Planning Application Ref: BR/190/20/OUT

Location: 26 Burnham Avenue, Bognor Regis, PO21 2JU

Description of works: Outline application with all matters reserved for up to 10 No. new dwellings with associated services, landscaping, car parking & amenity (resubmission following BR/49/19/OUT).

Mark Warwick
Tree Officer / Parks and Greenspace Team

SITE PLAN (PROPOSED) 1:200

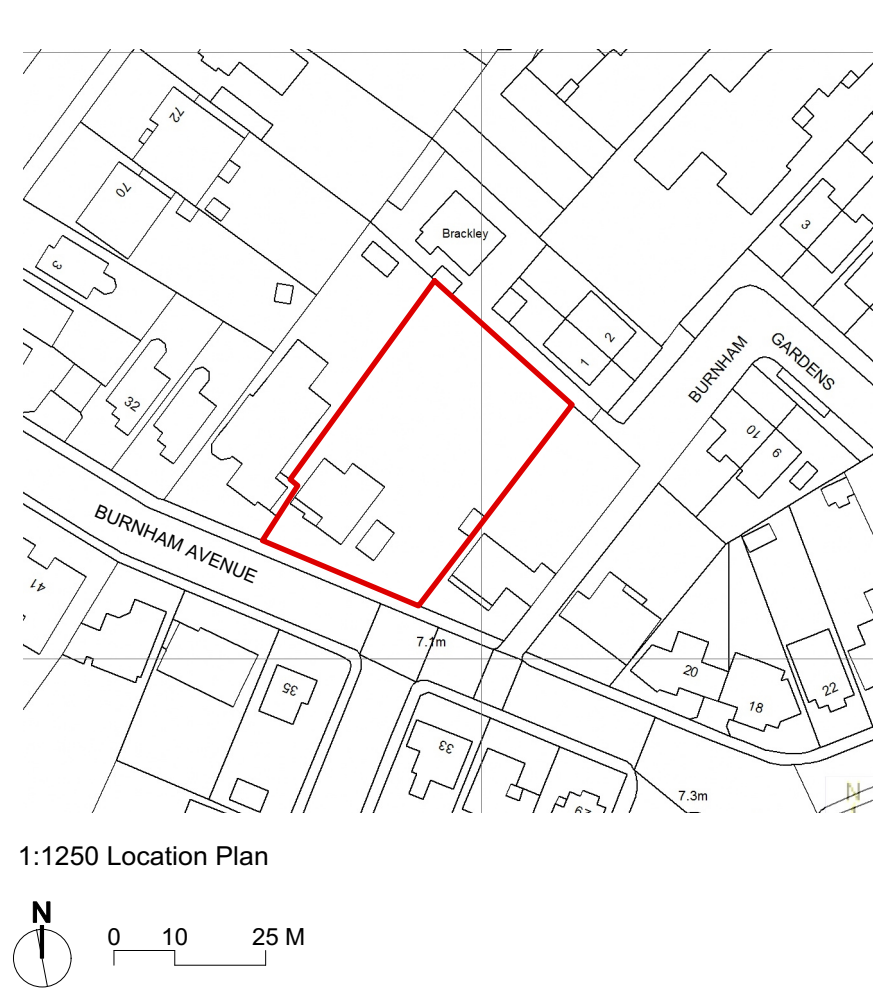
- I have considered this application by means of a desktop review, using the information and plans submitted as well as online resources.
- There appear to be significant trees at this site which will be adversely affected by the proposals. There is no supporting arboricultural information submitted with the application - a requirement of BS5837:2012. As such, were this application to now proceed, we will not have sufficient information to guarantee such trees would be adequately respected and protected.

1. The applicants will need to employ the services of an Arboricultural Consultant to carry out a tree survey exercise and then prepare an Arboricultural Implications Assessment (AIA) which must be inclusive of; a 'Tree Survey Schedule', a 'Root Protection Area (RPA) Schedule' and a 'Tree Constraints Plan' – with the trees accurately plotted on same.
2. In the event that a RPA of any tree which is proposed for retention overlaps the development then BS5837:2012 requires that the Detailed Planning Application is accompanied by an Arboricultural Method Statement (AMS) and also most importantly a Tree Protection Plan – to both describe and illustrate the mitigation measures which are to be employed to ensure that the trees survive without detriment to their vigour and vitality and are given adequate protection both above and below ground.
